Ms Amy Myer
Planning Officer
Arun District Council

Please find below my comments and objection to the planning application BN/128/19/OUT for the proposed development 70 bed Care Home and 14 Assisted Living bungalows with associated car parking, landscaping and access - Departure from the Development Plan.

SITE PLAN  
1/250

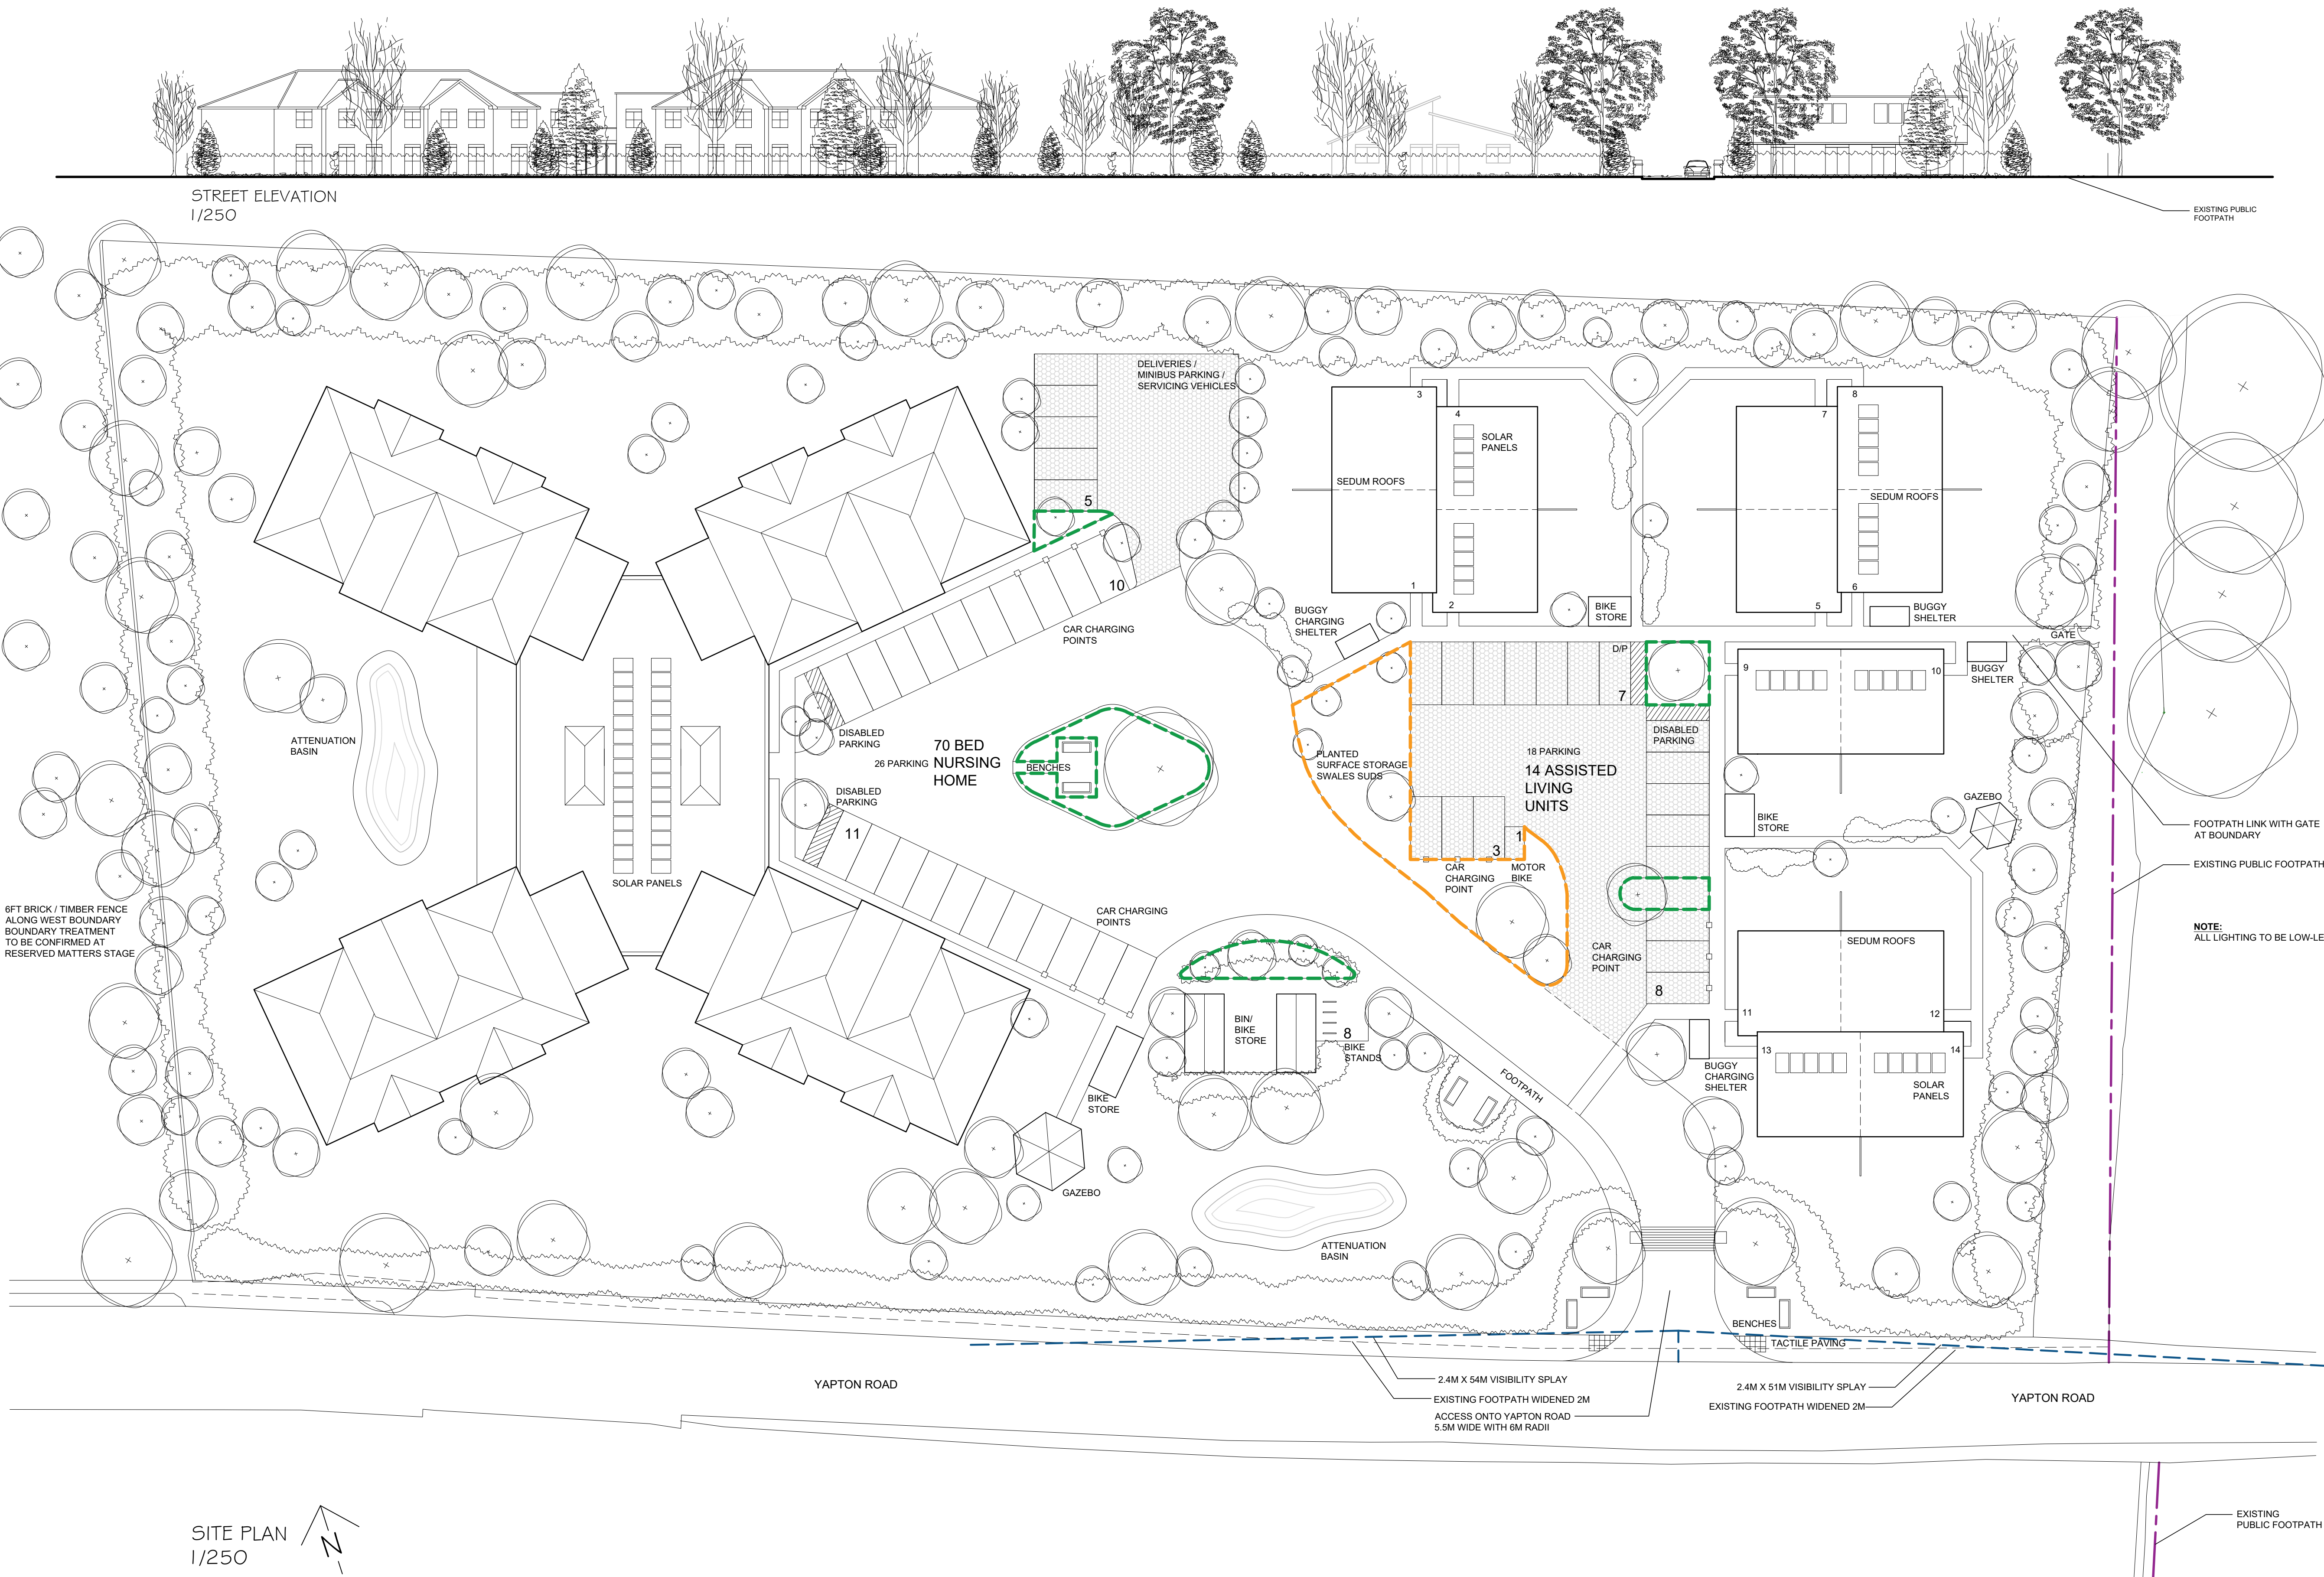
Currently, we have views of the South Down hills. This area of Yapton Road is semi-rural in nature. The development plans show 2 storey developments with elevated roof pitches. These are particularly high and not in keeping with the local housing style. Ultimately the proposed development will completely block our view of the South Downs. A Landscape visual Impact Assessment has not been submitted as part of the application that effects properties along Yapton Road.

involved surface water attenuation and soakage in to the ground. At present the drainage strategy is to develop a SUDs system using attenuation tanks for roof water and permeable pavement designs from roads and driveways.

Whilst we should support sustainable urban drainage (SUDs) schemes, no information has been presented on any proposed measures which should include pollution prevention of the water environment. Any SUDs scheme at this location will have to include treatment train principles of the highest design specification so that water quality discharges in to the ground are of the highest quality.

We object on ground of insufficient information on the surface water drainage proposals. The site does not support adequate geological conditions for development and could increase localised flooding.
